Our ref: AC/2021/130634/01-L01
Your ref: TR010044
Date: 4 November 2021

A428 BLACK CAT TO CAXTON GIBBET ROAD IMPROVEMENT SCHEME - THE EXAMINING AUTHORITY'S WRITTEN QUESTIONS AND REQUESTS FOR INFORMATION (WQ2)

Figure 2-8: River Great Ouse Proposed Permanent and Proposed Permanent Plus Temporary Works Design

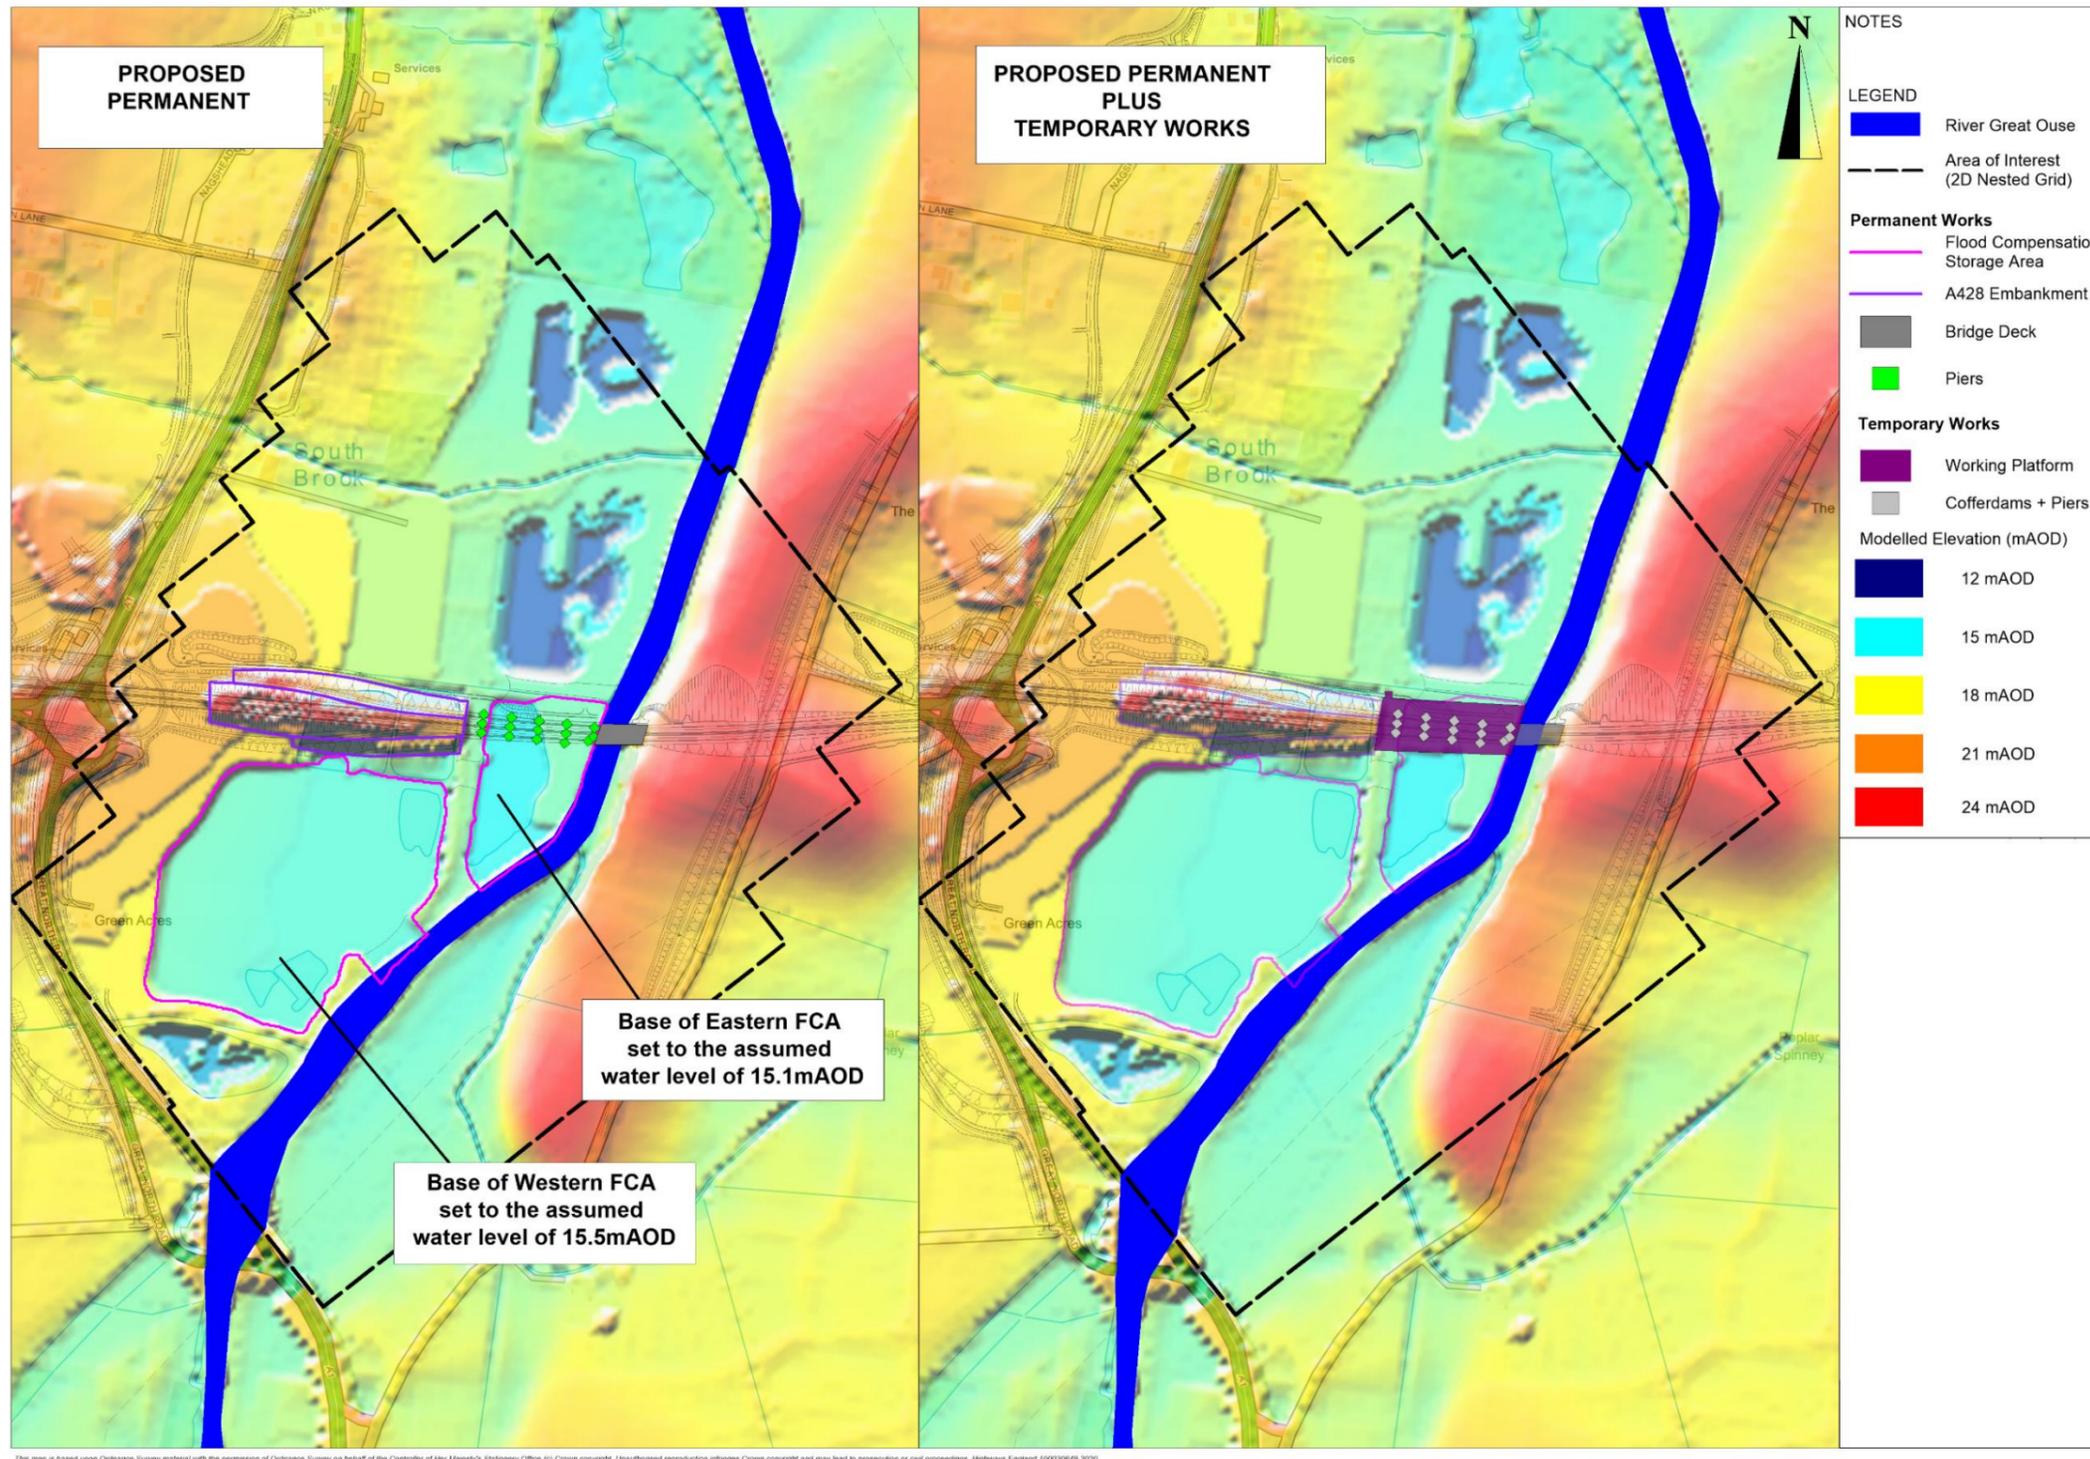
e) We are aware that four design options for the River Great Ouse crossing were considered in the scoping phase. We were consulted on a Technical Note for the River Great Ouse in 2019, which set out the flood risk implications of each of these four options and included the results of modelling that had been undertaken for each of the options. The preferred option was considered have the least adverse impact on flood risk. However, with the exception of the preferred option, we were not provided with any hydraulic models or details of compensatory floodplain storage for review.

We consider that a flood risk sequential approach was taken in the selection of the preferred option for the River Great Ouse crossing as the model results for the other options showed greater increases in flood levels. However, we are unable to confirm that the Applicant had appropriate regard to flood risk, including flood compensatory

storage, in all of their option development and selection work as we did not review the hydraulic models for the other options.
